RE: FORMER BARTONS INFANT SCHOOL, BERSTED
Council Ref: BE/40/22/PL

Technical Note in response to LLFA comments

This note has been prepared in response to the points raised in Arun District Council's memo to AC planning team.

Extract of utilities survey showing existing school outfall

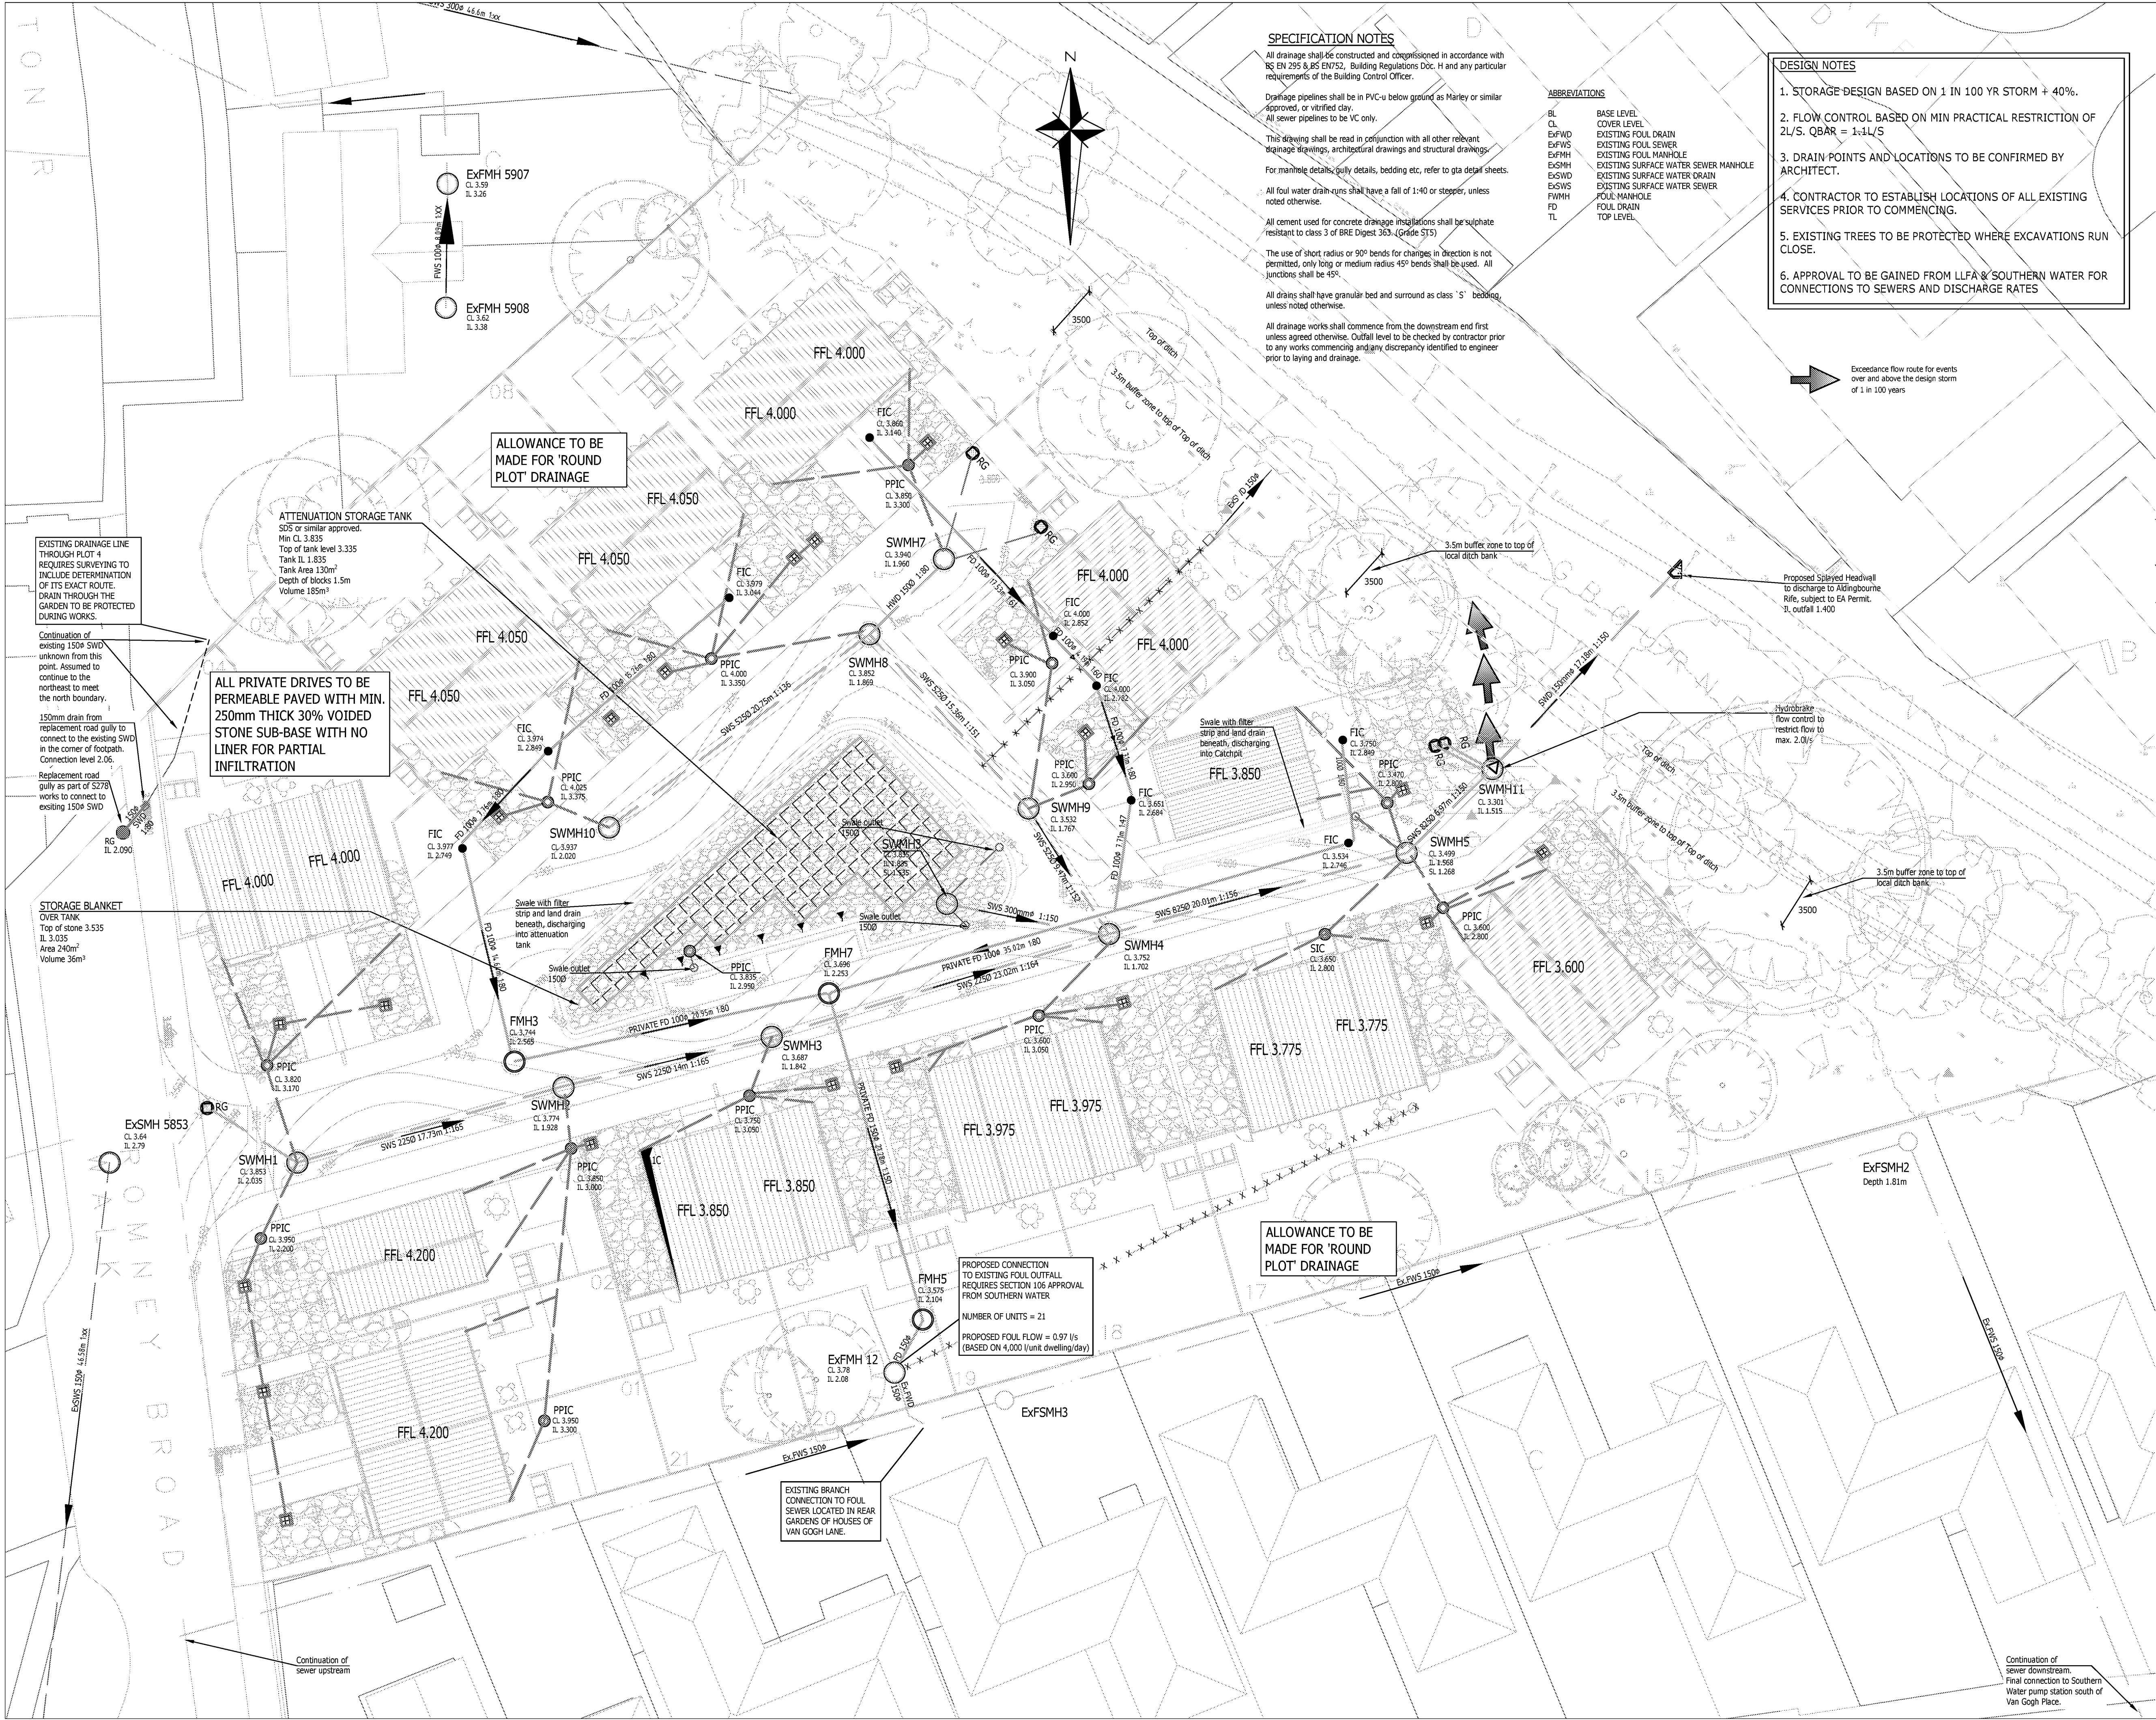
- 5) We are unsure how the ditch / small watercourse adjacent to the site connects to the nearby main river and we have concerns regarding how onward connection from the development site to this watercourse, or the main river will be achieved.

- The drainage layout shows the proposed onward connection to the main river crossing the smaller ditch channel. There is likely to be works required to facilitate the connection as shown, or to ensure the ditch / small channel is fit for purpose and has onward connectivity to the main river if a connection to this feature is proposed at the detailed design stage.

- We require additional details of the proposed connection, including whether an existing connection between the main river and smaller channel is present.

- We require details of how any pipework can be accommodated / will pass through the area where the existing ditch / channel is. This pipework should remain above the water level within the main river.

We have searched the area and we cannot find connectivity between the small watercourse and main river due to dense undergrowth.

The proposed connection is mimicking the existing school outfall location which is shown on the survey plan appended, extract below:

The only reason this existing outfall was not used was that it is not in a convenient location for future maintenance, as the manhole falls in the garden of plot 13.

The level of the existing outfall is likely to be somewhere in the region of 1.4m AOD (as upstream chamber is 1.54m) which is what we are proposing, so the new outfall will have no more impact than the existing, especially taking into account this used to have no flow restriction from the school site.

The main rife ditch bed level has been surveyed at approximately 1.020m AOD in the vicinity of the connection with no water level in the rife present. So the connection is 380mm above bed level which we feel is more than sufficient.
